DOC20/511367

26 June 2020

**Sydney Metro West (SSI 10038)
Advice on the Environmental Impact Statement (EIS)**

Figure 12-4: Sydney Olympic Park metro station construction site – heritage items and conservation areas

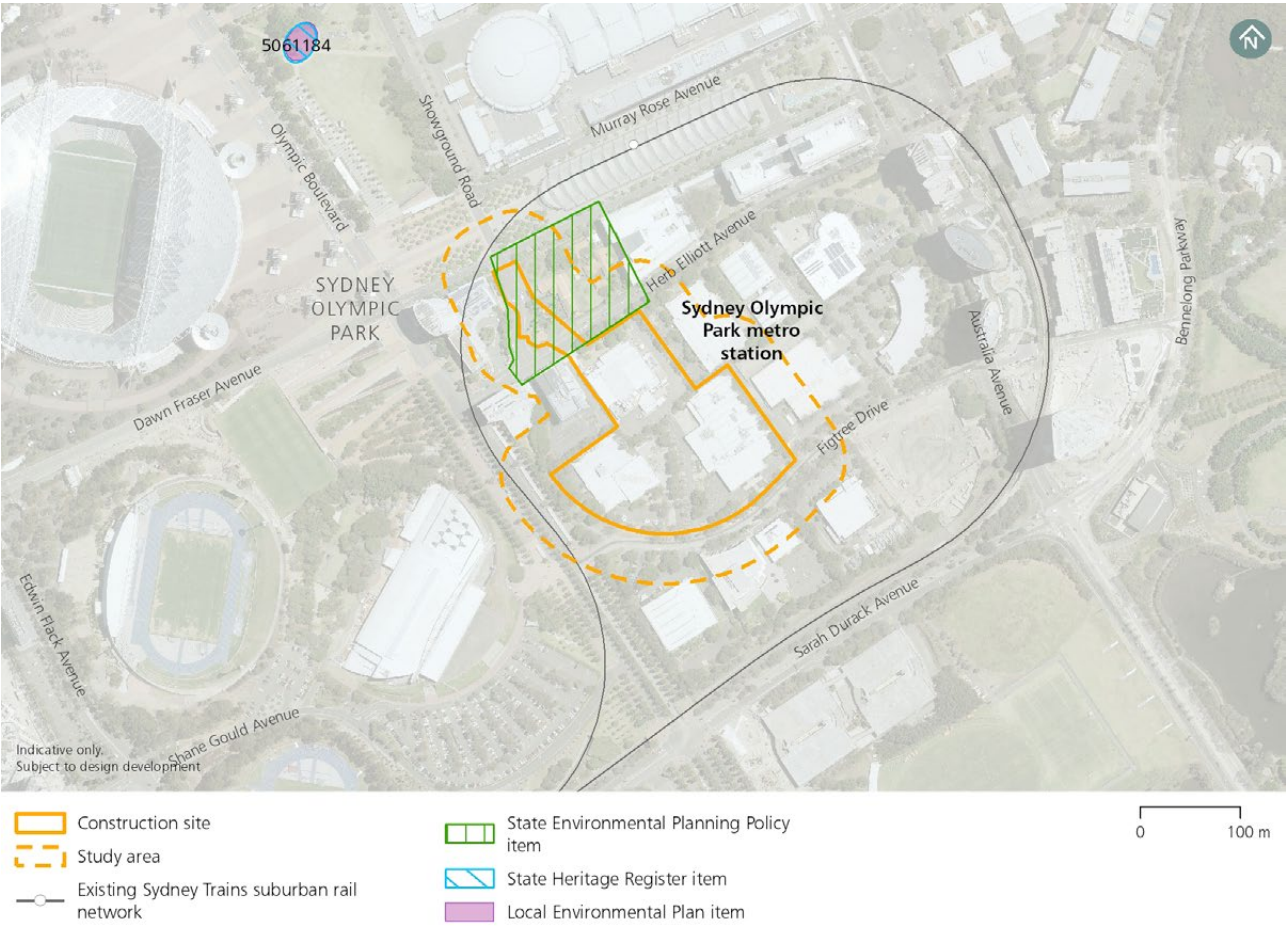
Monitoring location B.08 does not appear to be representative of residential receivers in NCA08. The monitoring location appears to be located adjacent to commercial land uses and away from the nearest residential receivers to the Olympic Park construction site. The noise monitoring graphs and information in Appendix B of Technical Paper 2 noise assessment indicate that measured noise levels are likely to have been influenced by existing industrial noise from nearby commercial buildings, particularly during the night.

The nearest residential receivers in NCA08 are distant to the potential sources of industrial noise near to the monitor. The proponent should provide justification that B.08 is representative of residential receivers in NCA08 or provide monitoring data that can be considered representative.
